Planning Application Reference:	17/02131/F
Location Of Development:	St Georges Catholic Church Round Close Road Adderbury
Proposed Development Details:	Demolition of existing chapel and erection of 1 dwelling

PLANNING APPLICATION 17/2131/F

No.15 North Elevation 1:100

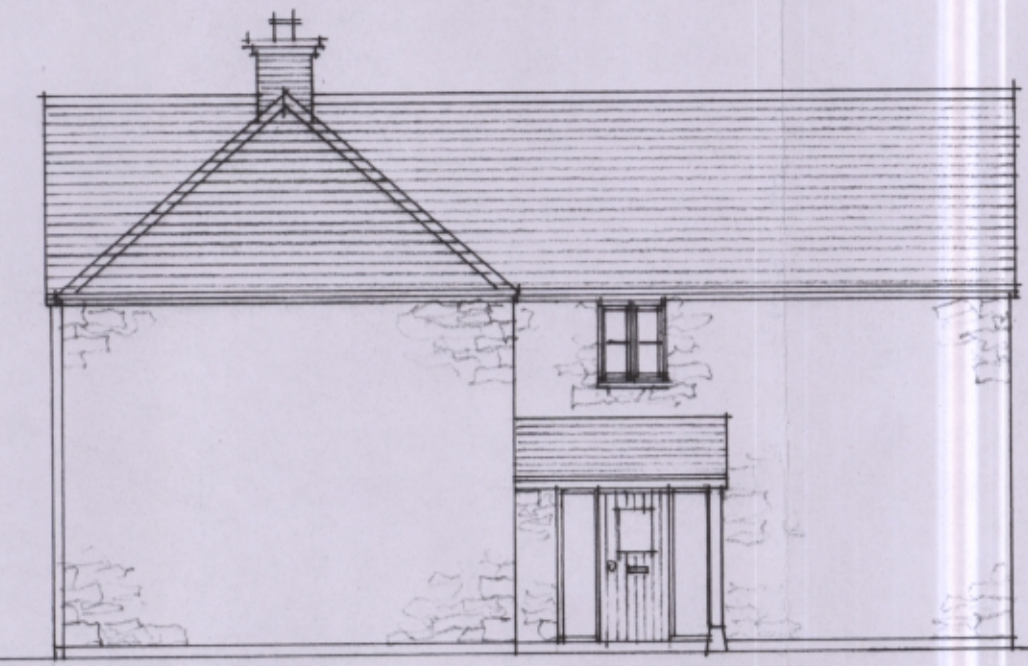
1. Measurements are difficult, from the plans, but it would seem that the light admission to my dining/family room window has not been obstructed. Could you confirm this?
